Please ask for: Mrs D Johnson
Email: daun.johnson@arun.gov.uk
Telephone: 01903 737762
Our Ref: LU/287/20/A
Your Ref:
Date: 19th October 2020

Application for Consent to Display an Advertisement(s)

Development: Retention of 2 No. internally illuminated fascia boards.
Location: Cassino Amusements 50 High Street Littlehampton BN17 5ED

Drawing Title:
PROPOSED PLANS AND ELEVATIONS
PROPOSED SIGNAGE

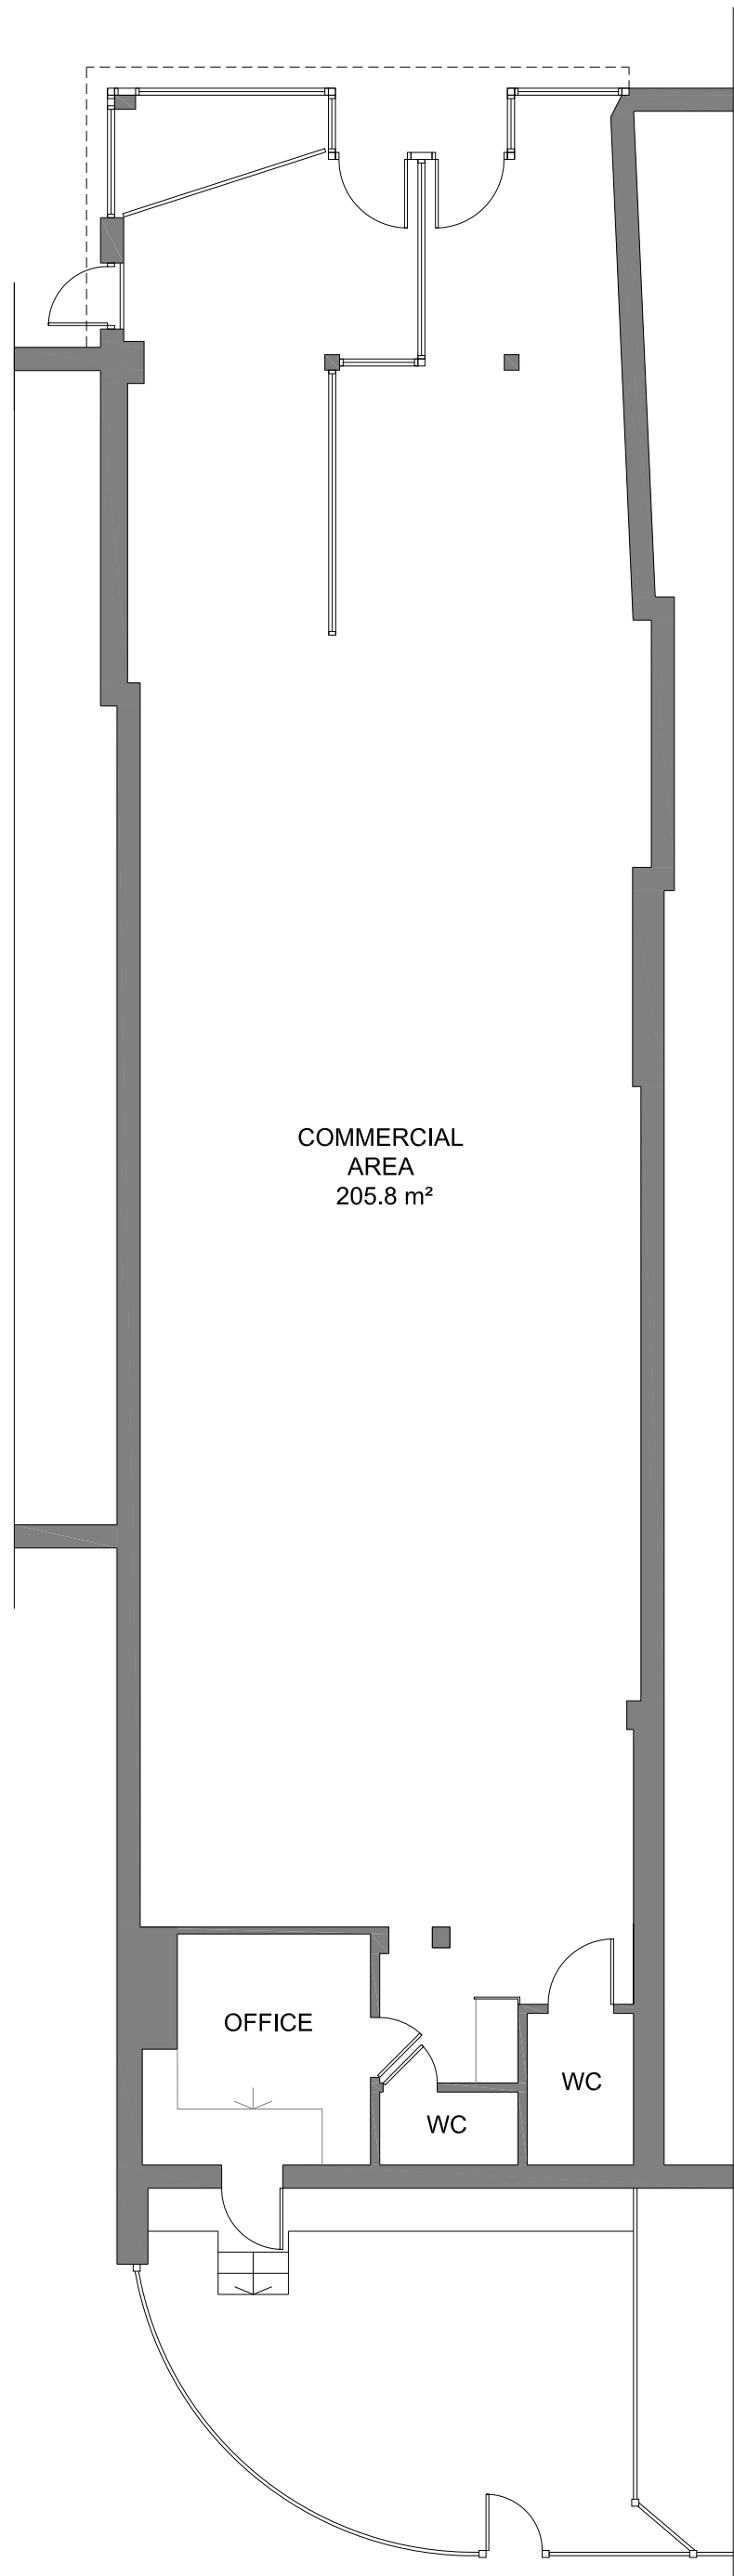
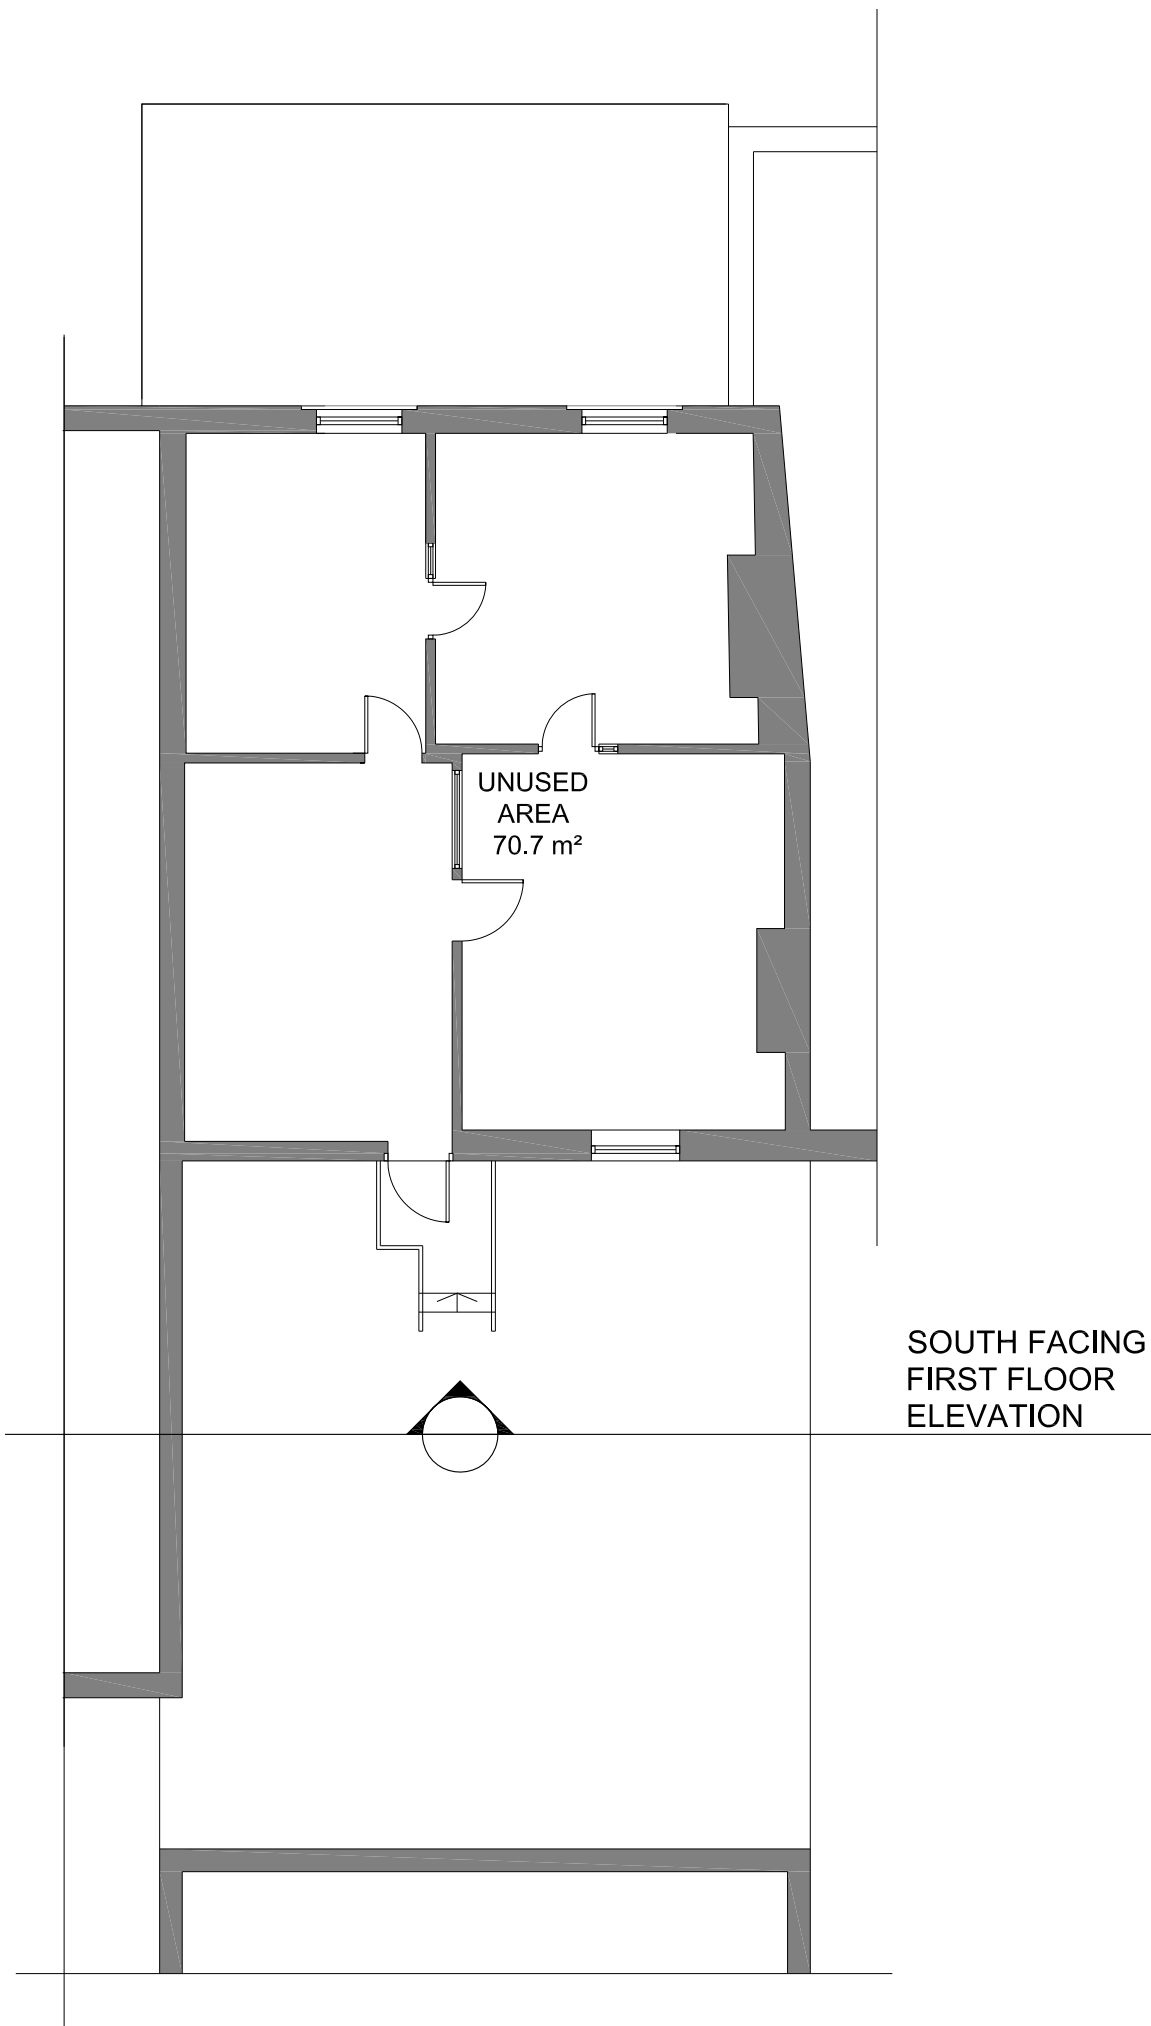
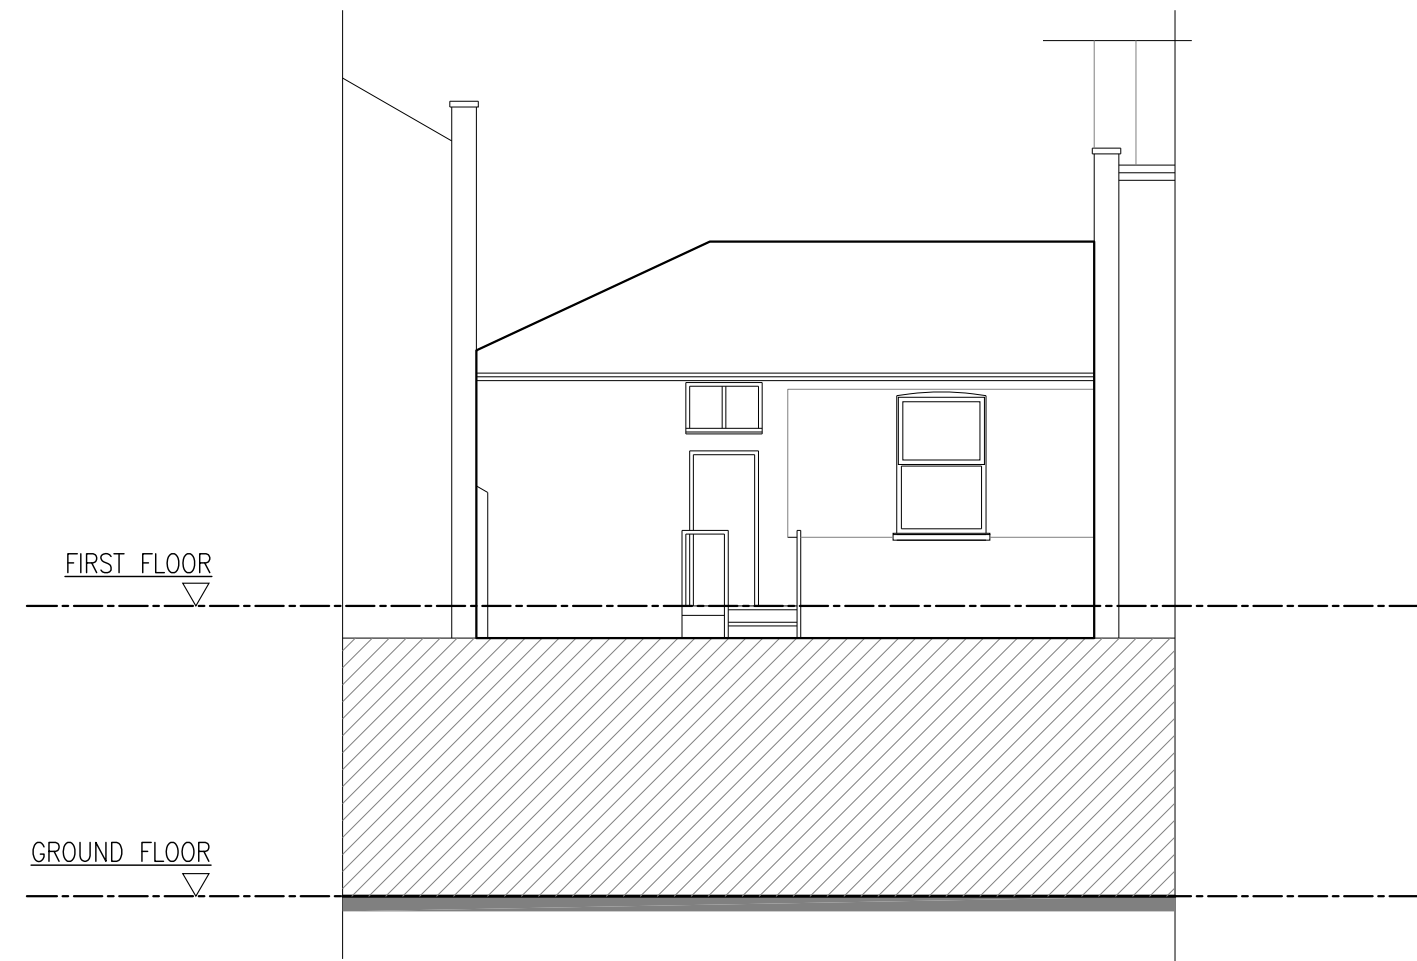
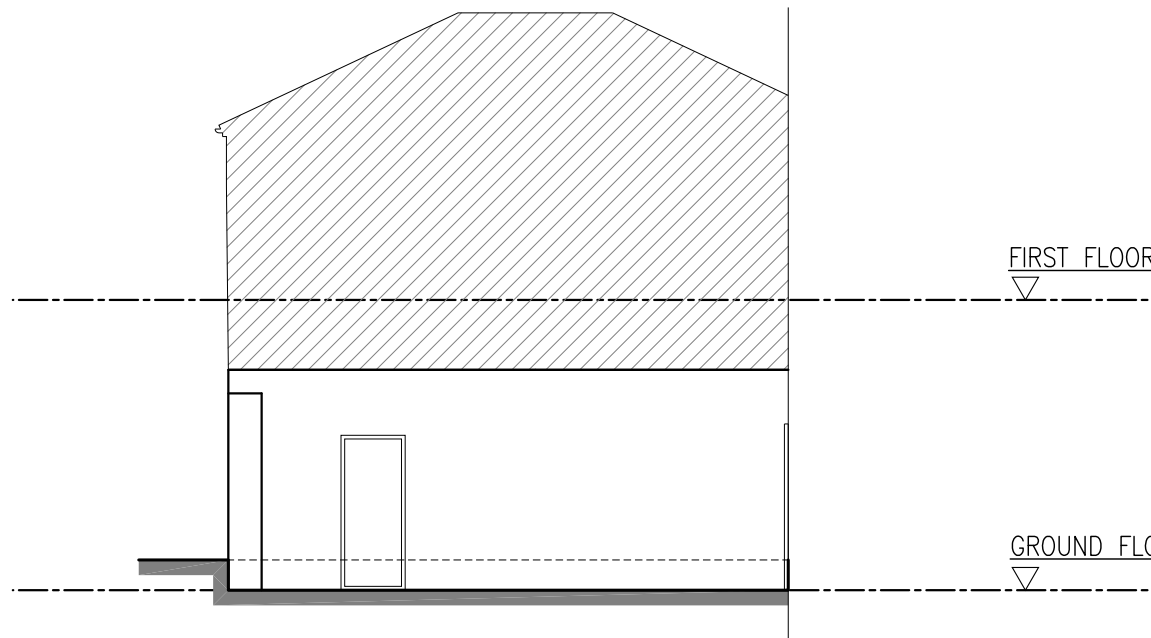
On the proposed elevations, please show the position of the adverts.
